Our ref: OUT25/8408

Subject: Cabbage Tree Road Sand Quarry Modification 4 (SSD-6125) – Modification Report

NSW DCCEEW Water Group has reviewed the Modification Report and makes pre-determination recommendations to:

Detailed advice to DPHI Planning & Assessment regarding the Cabbage Tree Road Sand Quarry Mod 4 (SSD-6125) – Mod report

Figure 1: Minimum Extraction Level for approved area and proposed extension

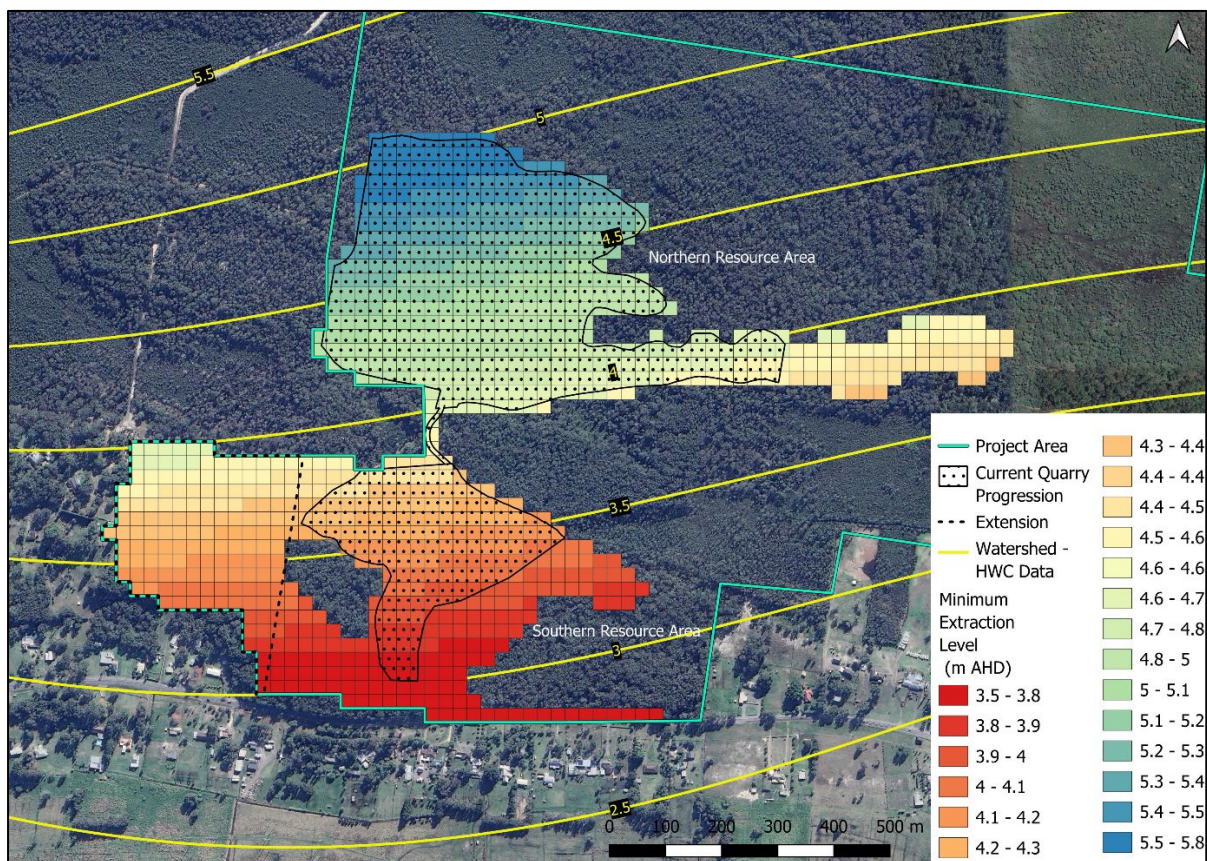
DCCEE Water identified significant variation between model predictions and observed groundwater levels in the northwest, where terrain is flatter and prone to recharge and ponding during heavy rainfall. This is determined to be due to the Minimum Extraction Level (MEL) that was projected across the Mod 4 area not accounting for the elevated topography of the Mod 4 area. To consider this further, DCCEE Water overlaid the MEL plot on Google Earth and projected a traverse from the nearest Hunter Water Corporation bore to estuarine mud flats, revealing higher groundwater levels along the northern boundary.

DCCEE Water notes a greater risk of non-compliance with Schedule 2, Condition 6, which requires excavation to remain at least 0.7 metres above the predicted maximum groundwater level. This is further supported where Groundwater Exploration Services (GES, 2025) observed the greatest deviations from model predictions near BH11 in the northeast, where catchment relief is low.

Further assessment and review against the design of the project is required.

Figure 2: Groundwater Monitoring Network

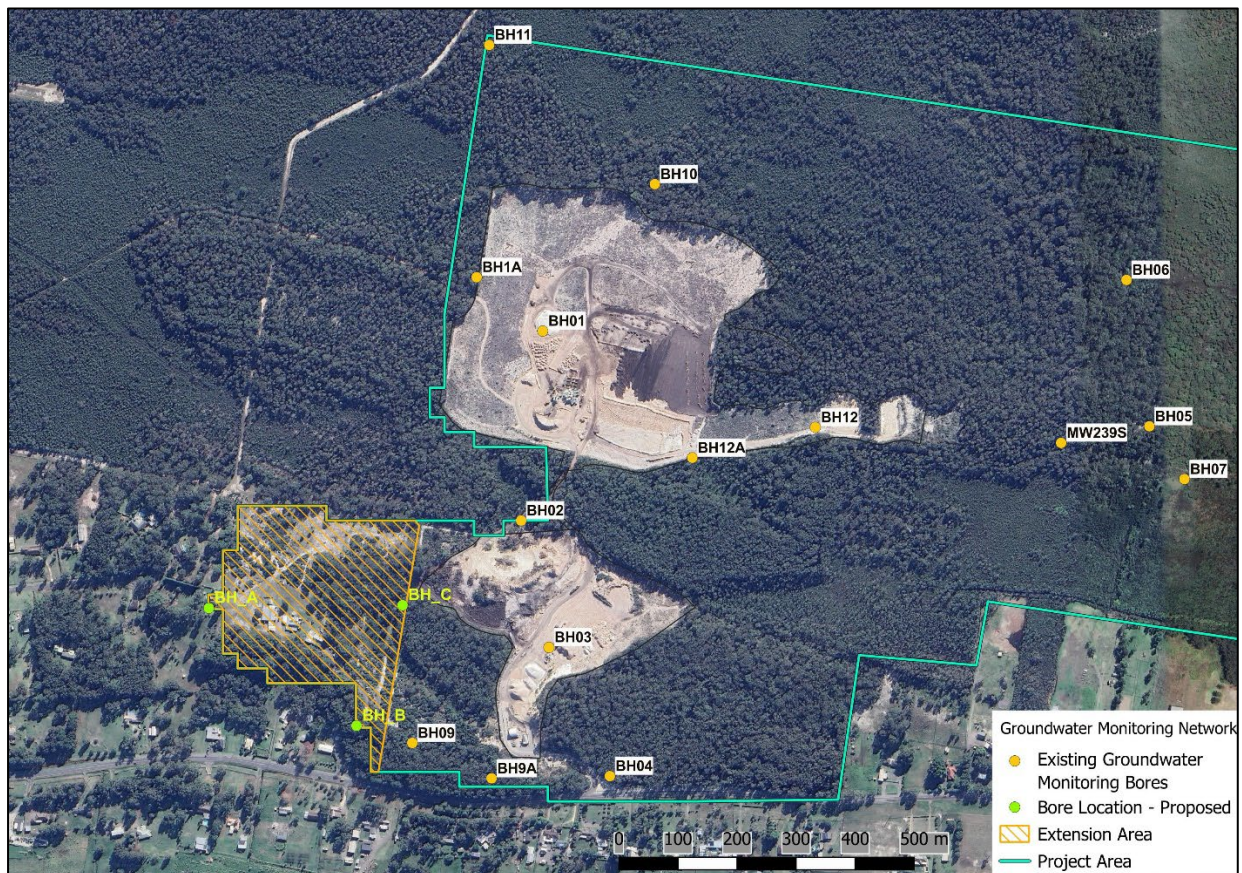
The Department of Planning, Housing and Infrastructure requests the proponent to install additional groundwater monitoring location(s) along the northern boundary of the proposed western extension area and include them in the existing monitoring program alongside the consultant recommended sites.

Whilst GES recommends installing three new monitoring bores in the southern part of the western extension, DCCEE Water recommends additional monitoring along the northern boundary to:

- Track groundwater levels more accurately.
- Ensure MEL compliance.
- Support adaptive management of quarry operations.
